DATE: May 27, 2015
TO: Jack Cloud, DRB Chair
FROM: Catalina Lehner, Senior Planner *CLL*
RE: Project #1004763, Montgomery Zone Change
As-Built Site Development Plan for Building Permit

Staff reviewed an updated version (v.3) of the as-built site development plan for building permit (no revision date provided). Staff notes the following:

Re: Official Notification of Decision April 9, 2015
Oasis Family Church
7500 Montomery Blvd.

EXTERIOR HANDICAP RAMP

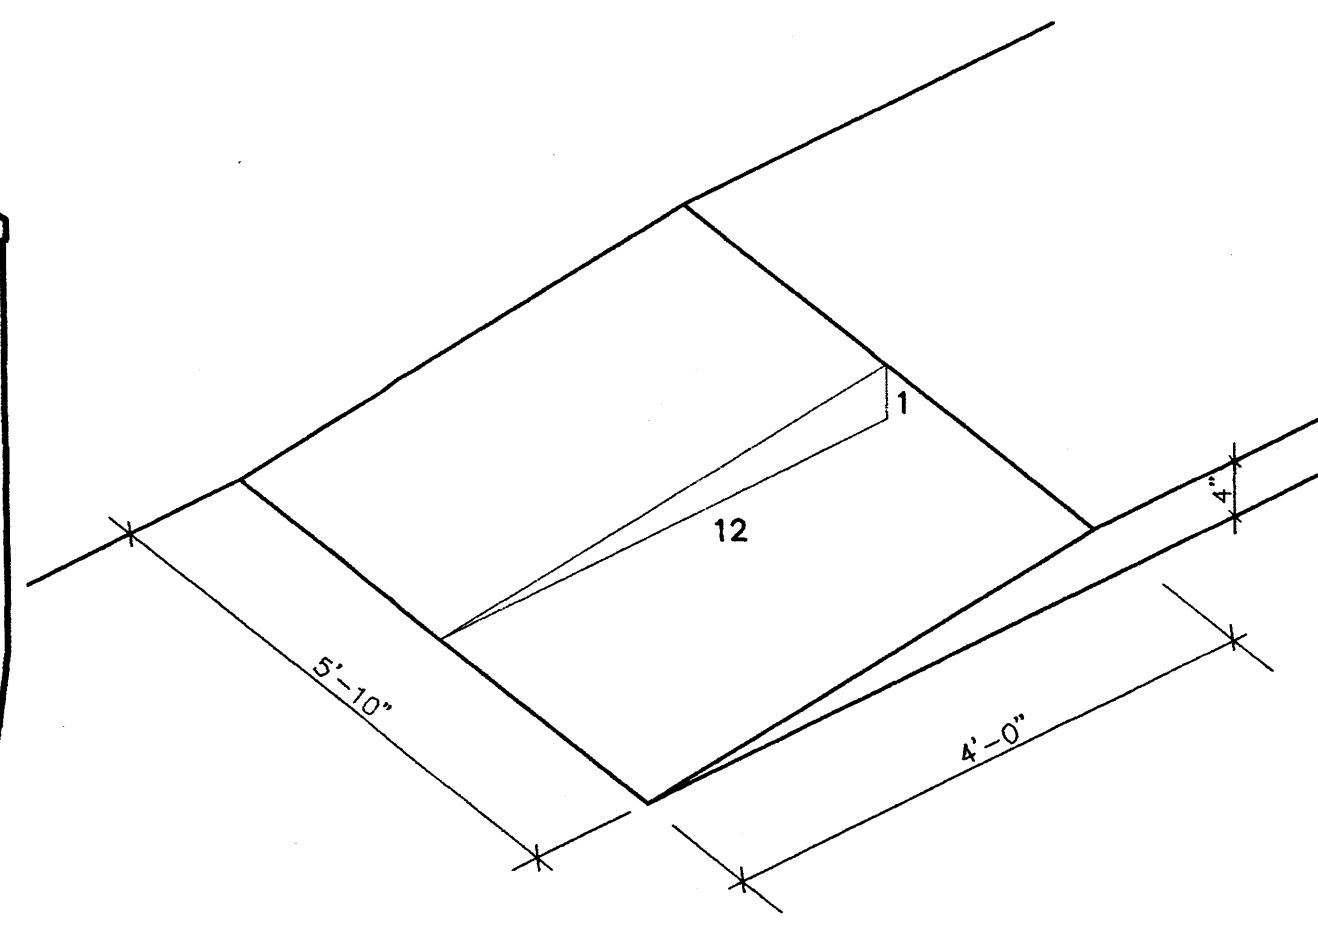
- J. Label existing slopes of the ramps from the handicapped spaces along the east side of the building. These slopes need to be a maximum of 1:12.
- K. Developer is responsible for permanent improvements to the transportation facilities adjacent to the proposed development site plan, as required by the Development Review Board (DRB).

J. Label existing slopes of the ramps from the handicapped spaces along the east side of the building. These slopes need to be a maximum of 1:12. Response: Existing ramps have been indicated with slope of 1:12.

ACCESSIBLE PARKING SIGN

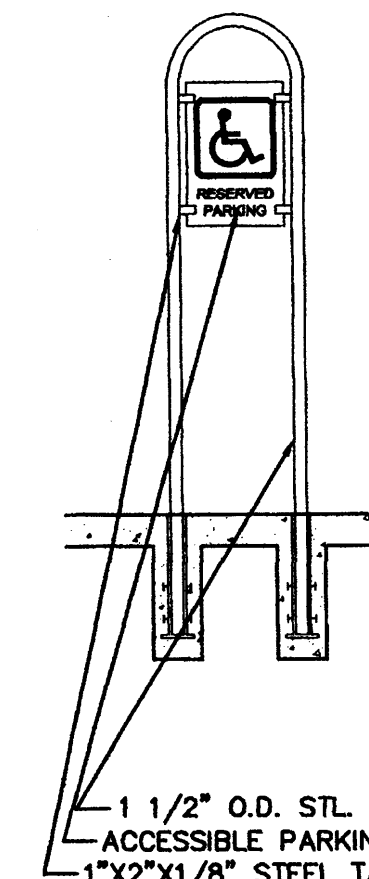
F. For the ADA accessible parking sign, label where it applies on the plan view. Provide an ADA van accessible sign for the two required van accessible spaces. (2 are required for the 102 parking spaces.) The ADA van accessible sign must have the required language per 66-7-352.4C NMSA 1978 "Violators Are Subject to a Fine and/or Towing."

F. For the ADA accessible parking sign, label where it applies on the plan view. Provide an ADA van accessible sign for the two required van accessible spaces. (2 are required for the 102 parking spaces.) The ADA van accessible sign must have the required language per 66-7-352.4C NMSA 1978 "Violators Are Subject to a Fine and/or Towing." Response: Existing signage is in place at parking spaces. Owner will add two more signs for ADA van access.

MONUMENT SIGN

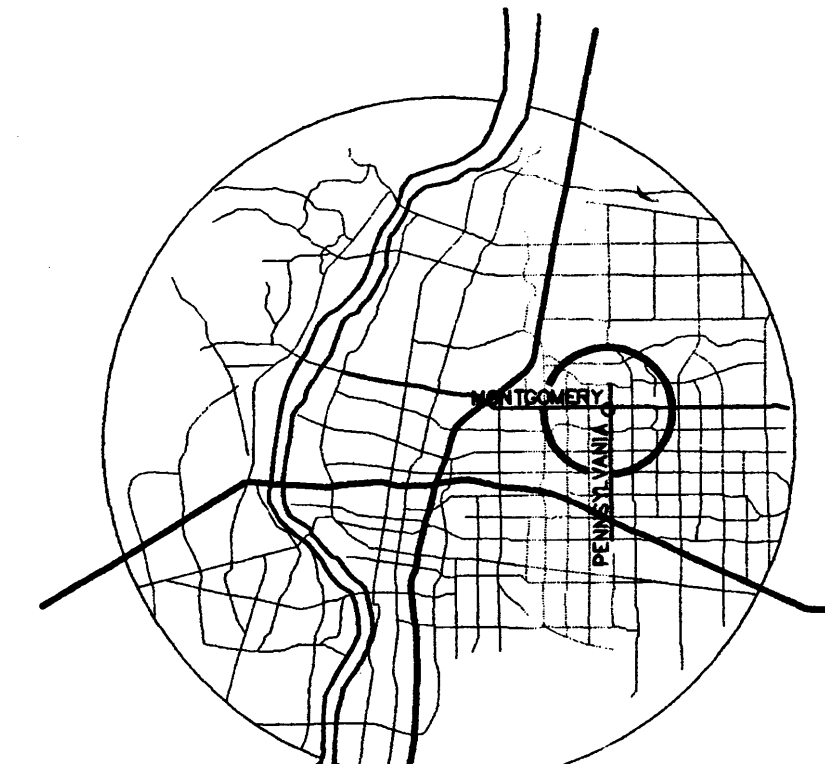
6. Signage: The monument sign detail shall specify colors, materials and illumination type.
7. Elevations:
A. A brief narrative shall be added to describe the existing building's finishes, materials and colors.

A. The monument sign detail shall specify colors, materials and illumination type. Response: A photo graph of existing monument sign has been attached to drawing and noted as being interior illuminated.

AS-101 N.T.S.

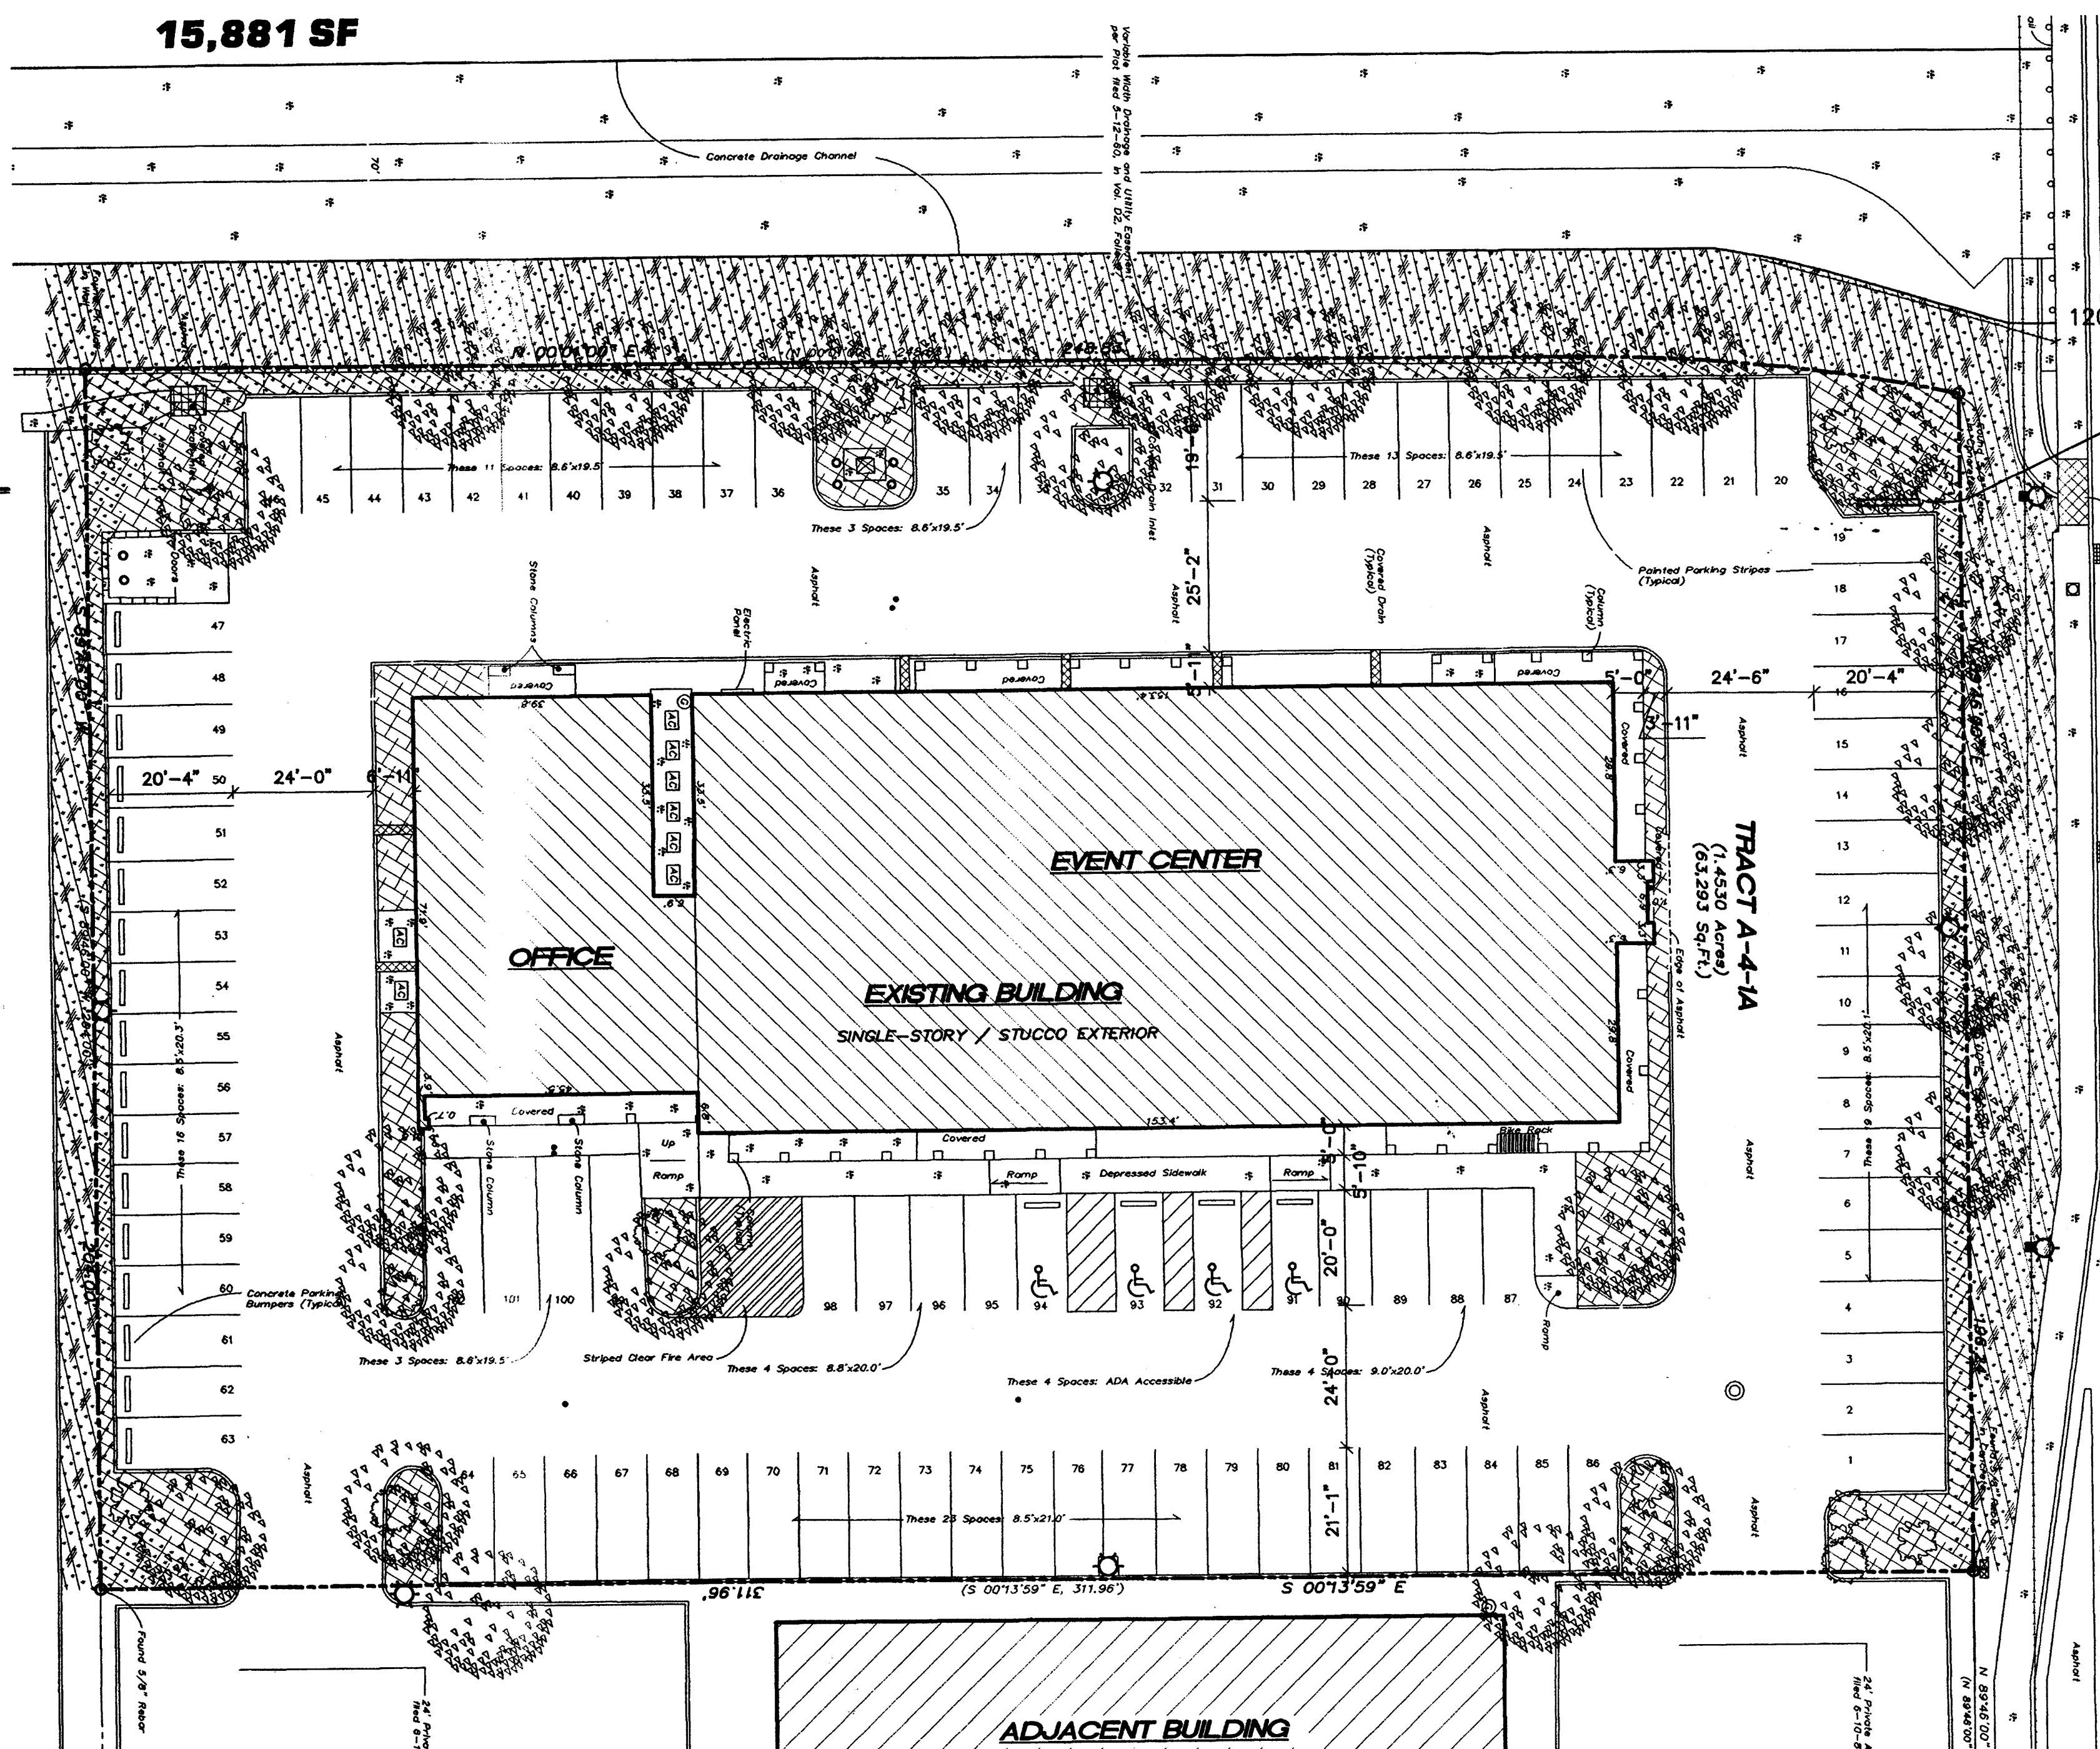
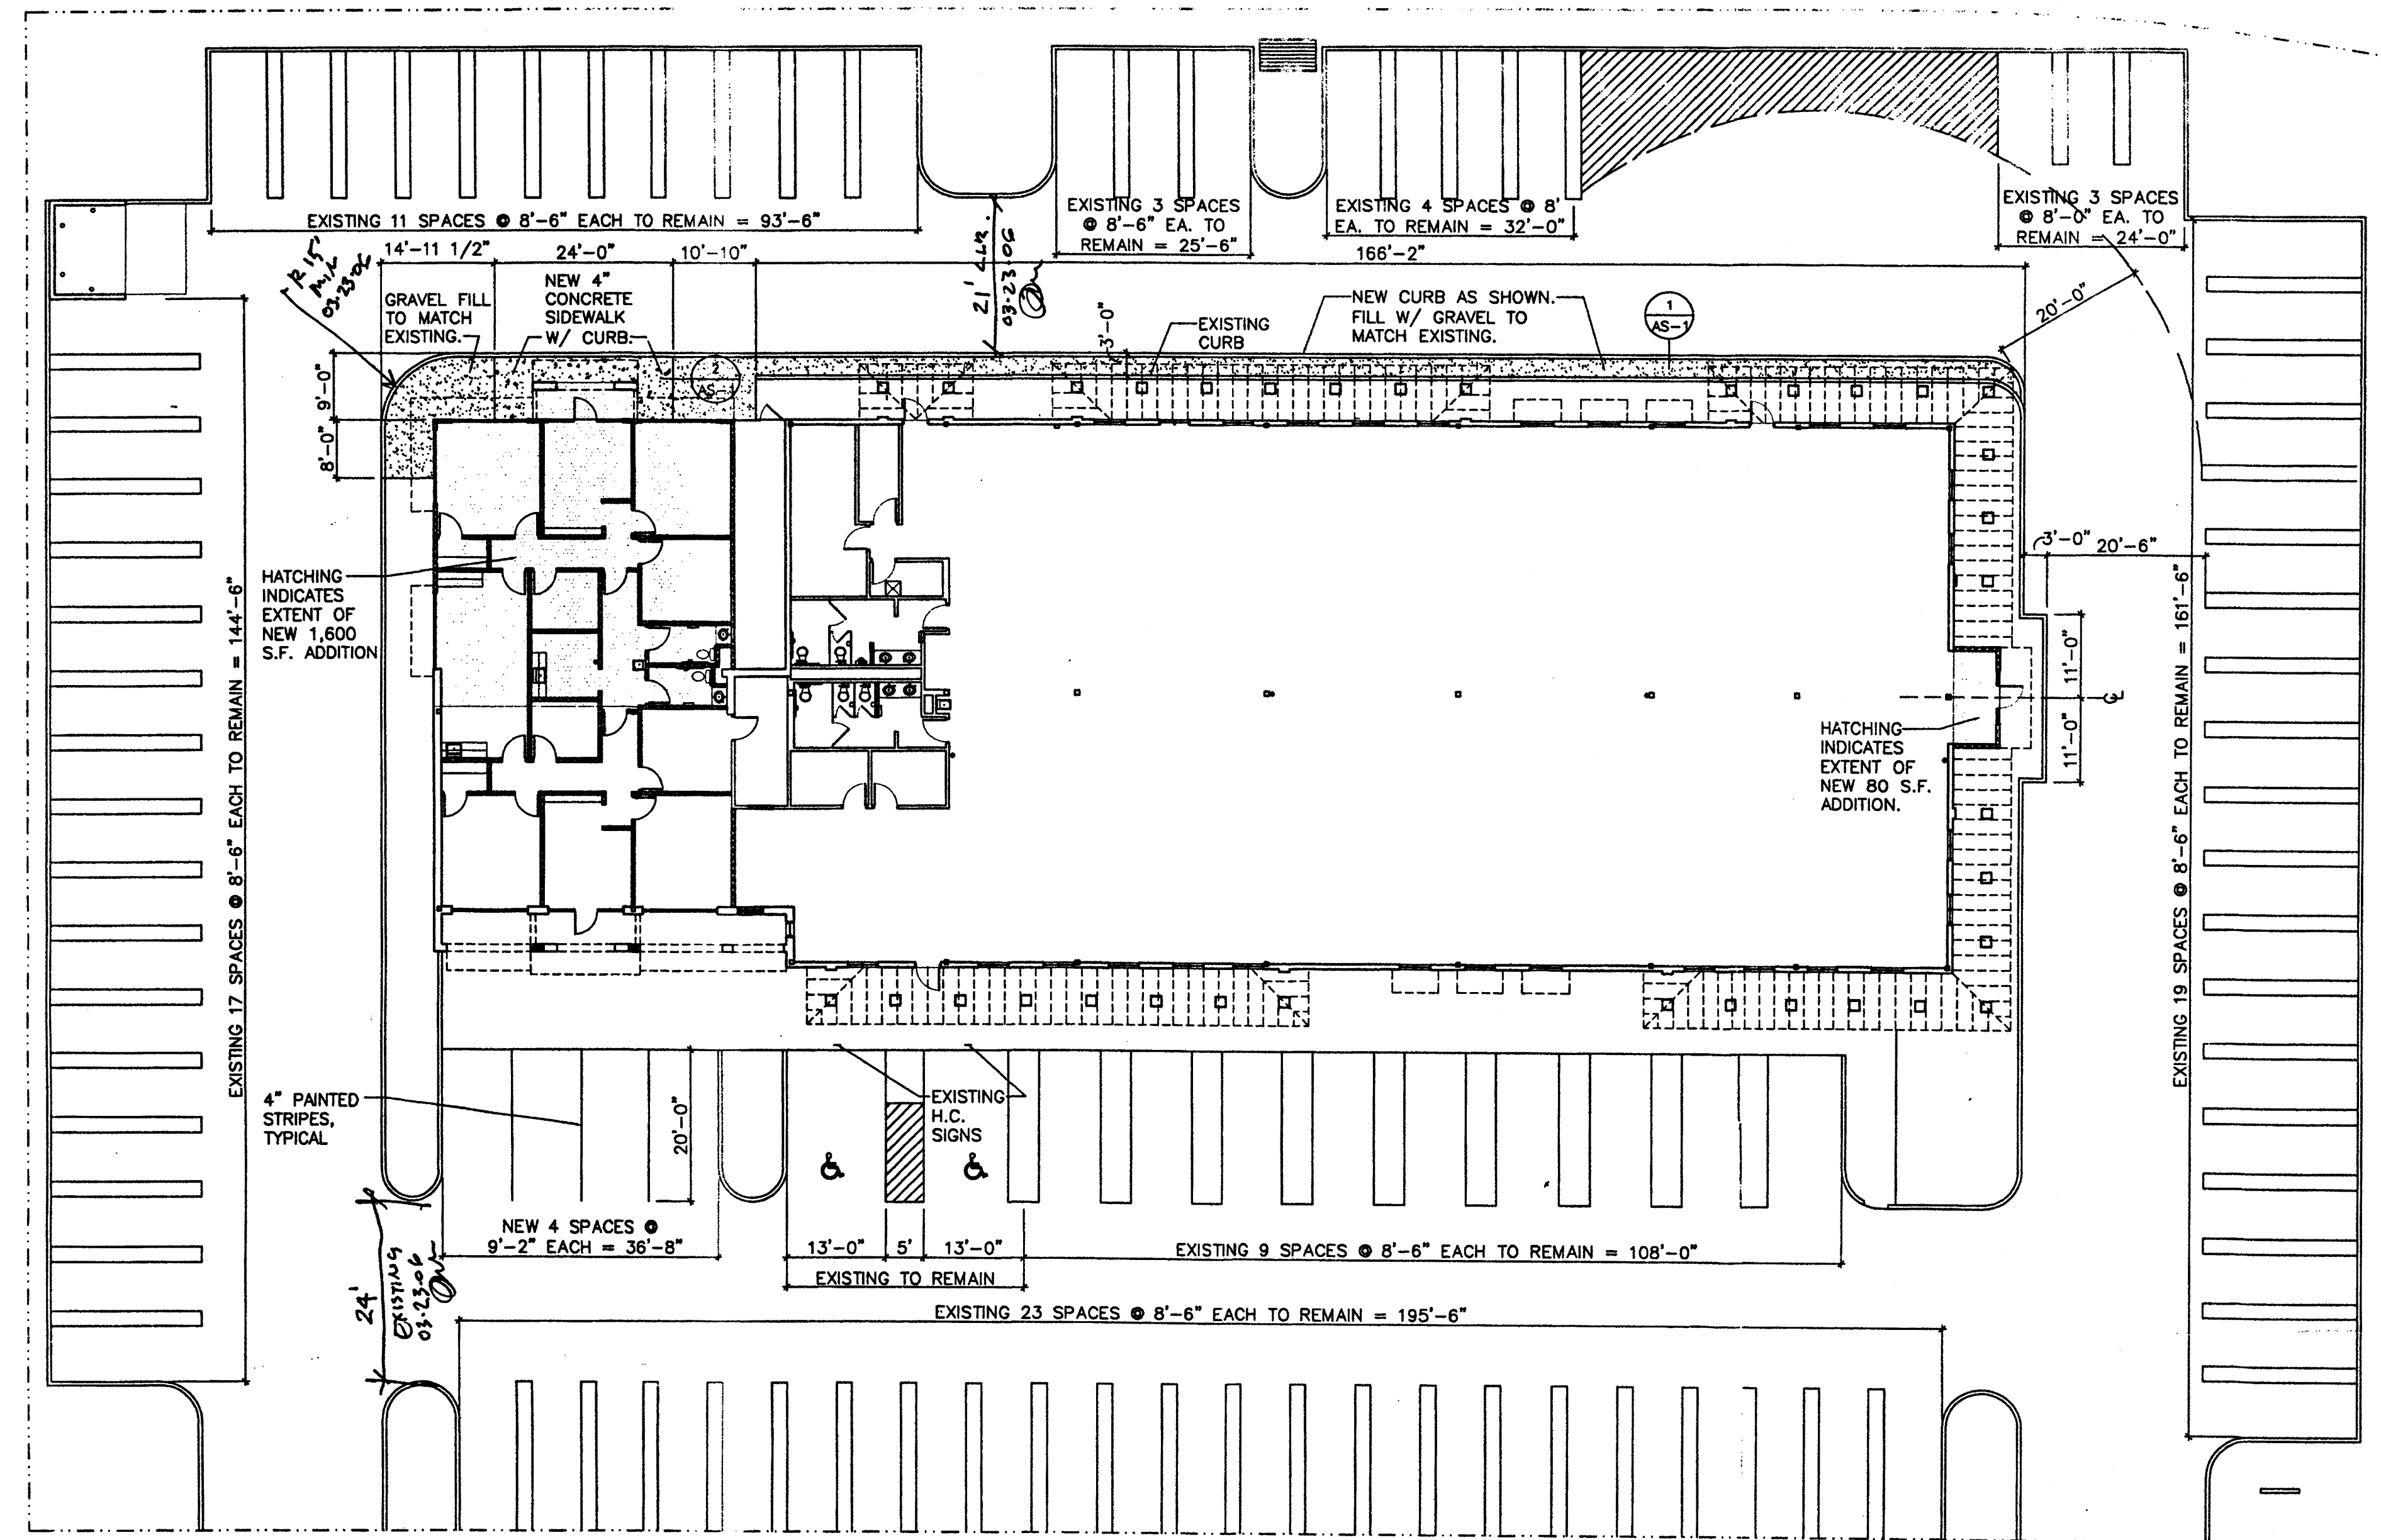
Condition #3A- Parking: Calculations for handicap, bicycle and motorcycle parking were handwritten onto Sheet 1.

Condition #7b- Elevations: Notes were added to Sheet 1 to address the height, materials, finish and color of the refuse enclosure.

A. Clearly show north arrow on plan view (Sheet C-1).
B. Label existing sidewalk width adjacent to site along Montgomery Blvd. NE.
C. Label width of handicapped parking spaces and aisles along the east edge of the existing building. The handicapped parking spaces must be a minimum of 8.5 feet in width, and the van accessible aisle must be a minimum of 8 feet in width whereas the rest of the aisles shall be a minimum of 5 feet in width.

D. Label all existing parking spaces that are to remain as "existing". If any parking spaces are proposed to be repainted, label them as "proposed" spaces.

Response: Number of spaces required by code have been noted on plan: per 14-16-3-18 Street Parking – 8 handicap spaces, 8 motorcycle spaces, 6 bicycle racks.

B. Four more handicap (HC) spaces, and 4 motorcycle (MC) spaces, shall be provided. Response: four more spaces added and noted, 4 motorcycle spaces have been dedicated for a total of 8;

C. The bike rack shall be labeled and number of spaces specified. Response: six existing bicycle parking spaces have been noted on dwgs and photo provided on plan.

A. Clearly show north arrow on plan view (Sheet C-1). Response: North arrow has been clearly shown on plan.

B. Label existing sidewalk width adjacent to site along Montgomery Blvc. NE. Response: width was called out on drawing as 6'.

C. Label width of handicapped parking spaces and aisles along the east edge of the existing building. The handicapped parking spaces must be a minimum of 8.5 feet in width, and the van accessible aisle must be a minimum of 8 feet in width whereas the rest of the aisles shall be a minimum of 5 feet in width. Response: spaces and dimensions were shown on plan.

D. Label all existing parking spaces that are to remain as "existing". If any parking spaces are proposed to be repainted, label them as "proposed" spaces. Response: All spaces have been indicated as "existing". None are to be painted.
